Reference: 1296-1300 Carling Avenue
Response to Major Zoning By-Law Amendment Application Formal Review
Our File No.: 3697

Please find below our responses to the consolidated comments from the third review of the above noted application, dated October 28, 2025.

1296-1300 Carling Avenue | Informal Review | Zoning By-law Amendment | Architects DCA, James B Lennox & Associates Inc. Landscape Architects |

Figure 17: Tower separation distance to abutting properties

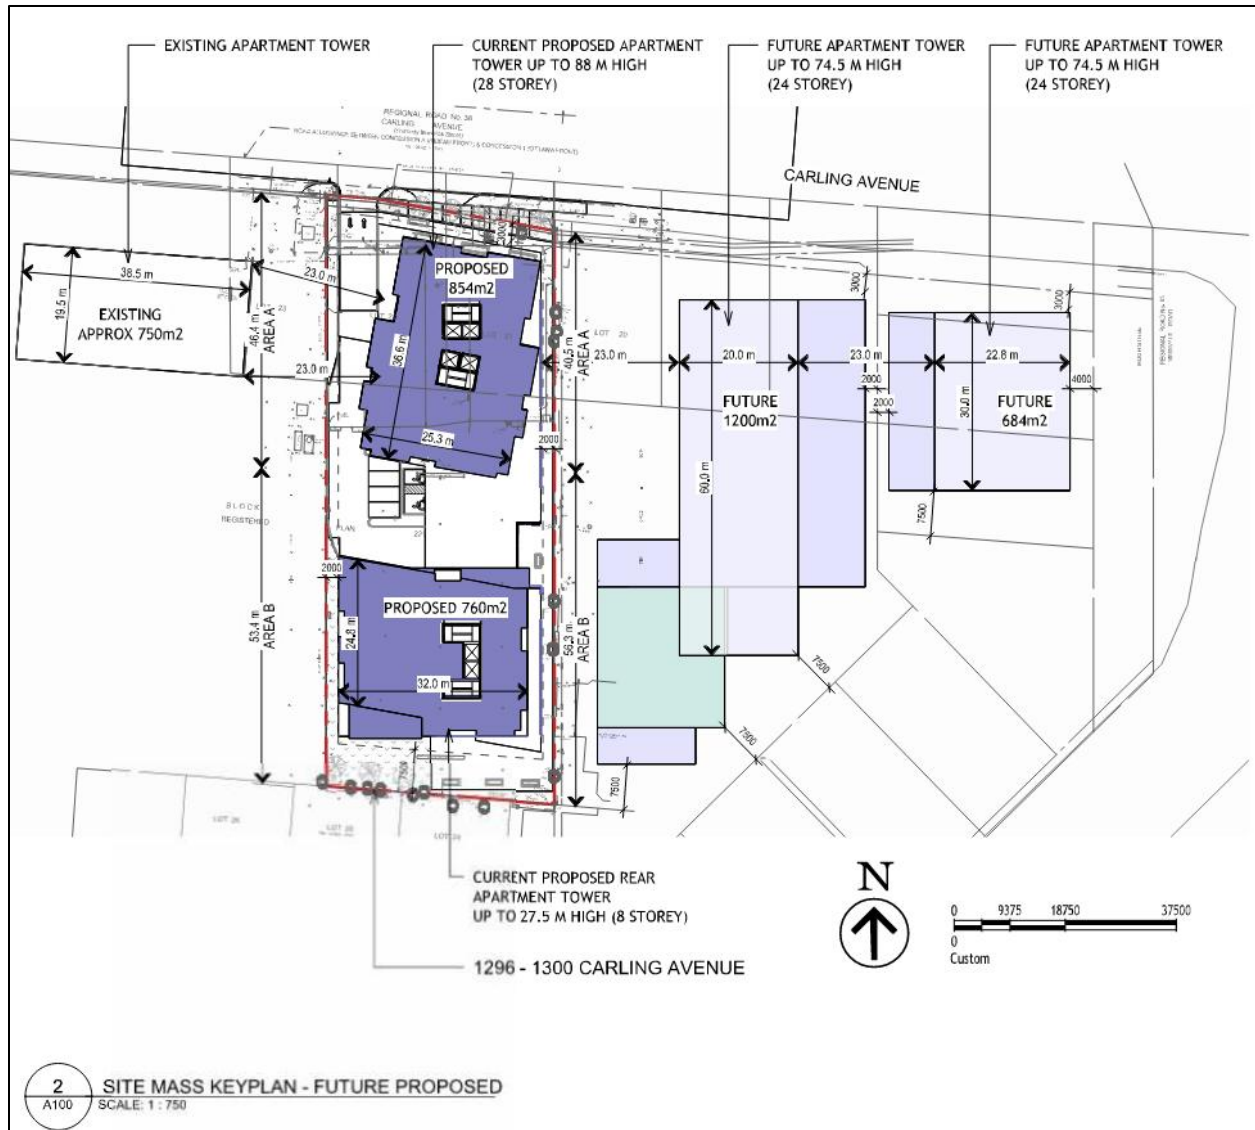
3. The Panel encourages the applicant to consider how the building relates to adjacent properties and recommends coordinating with the neighbors to achieve a more cohesive block plan. A block plan which is accepted by both neighbours.

Response: Noted. Tower and podium relation to street and neighbours will be reviewed for site plan application. Note that tower separation guidelines and massing for development potential of lands to the east have been considered.

Conceptual Site Plan

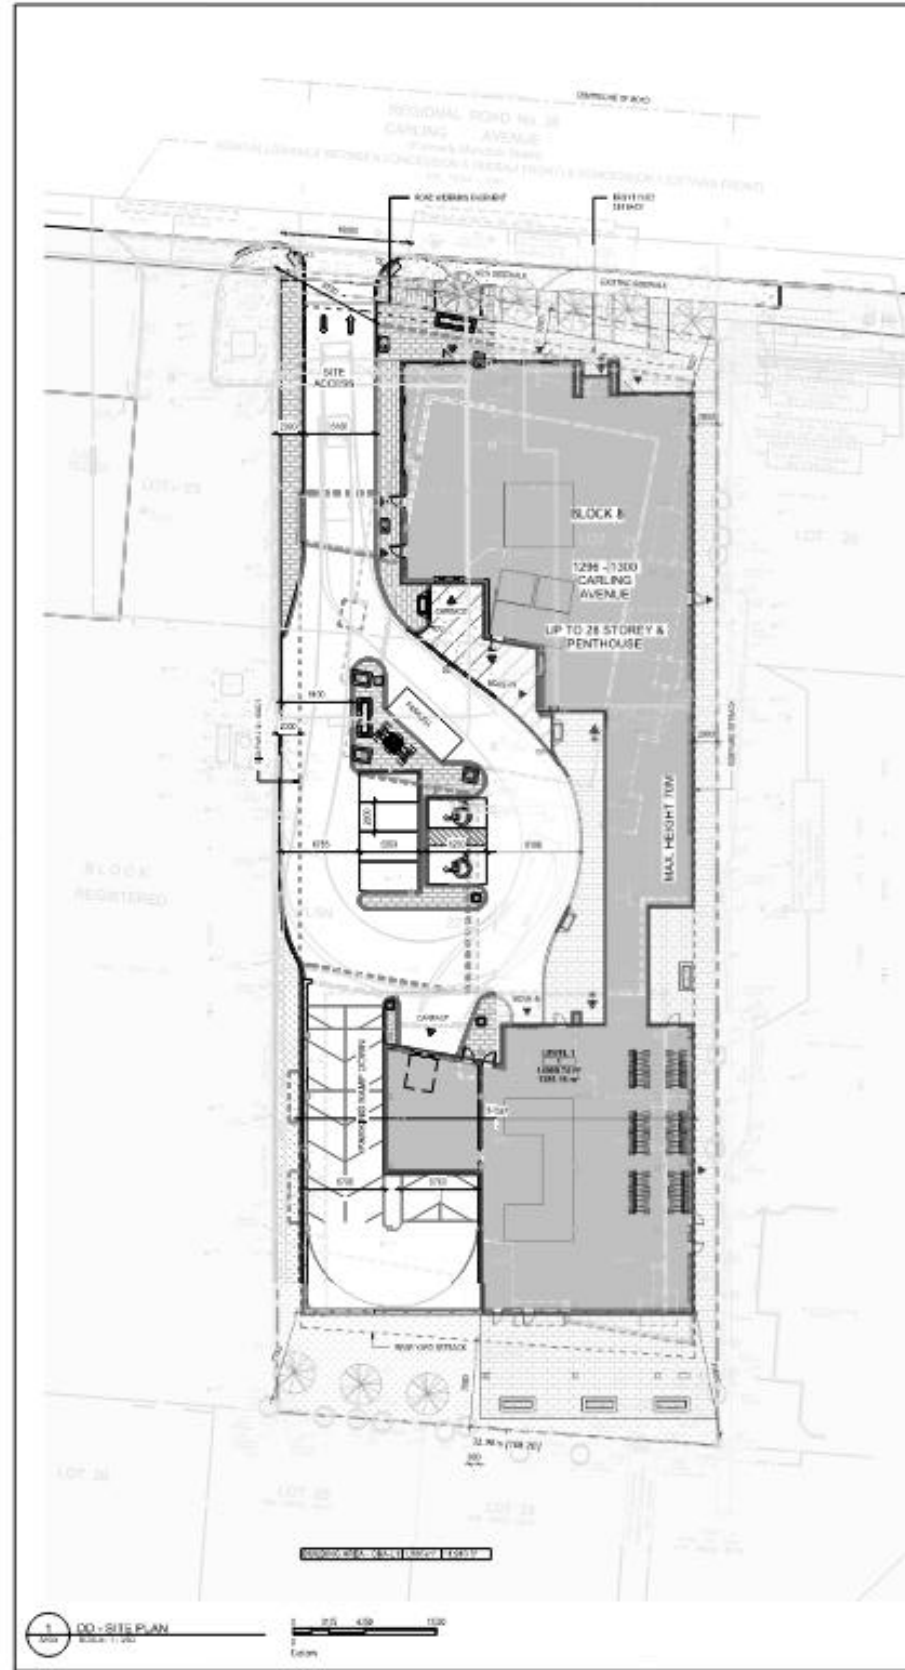
1. The Panel recognizes the intent to create an animated and pedestrian-oriented streetscape but notes that the current site layout appears heavily dominated by vehicular movement, particularly at the roundabout and service areas.

- i Consolidating access points and service functions, along with increased soft landscaping, is recommended to create a more welcoming and human-scaled entry sequence.

2. The Panel highlights challenges with ground floor design and encourages stronger linkages to the rear outdoor amenity spaces and careful consideration of how service areas, garbage, and pick-up zones interface with the pedestrian environment.

- i The Panel suggests long blank walls along the east side of the building be articulated through glazing or other façade interventions to improve visual interest and human scale.

4. The Panel recommends enhancing the courtyard and internal circulation with soft landscaping and thoughtful pedestrian pathways, to improve livability.

Response: Roundabout dictated by truck turning radius, but access and courtyard spaces will be reviewed for site plan application. It is important to note that part of the approach is to develop the interior space as a courtyard that accommodates the necessary truck movement (moving vans, garbage, deliveries) off-street, reducing the impact of potential challenges on Carling.

Response: As noted, access and pedestrian use of site will be reviewed for site plan application; design feedback has been considered and, for purposes of rezoning, a refined approach to rear yard amenity space has been developed.

Response: Review of pedestrian circulation on site will be done for site plan application but intent is to create a courtyard-like space with pavers and flexible uses to create less of a sense of vehicle dominance while providing the necessary access requirements for a functional building.
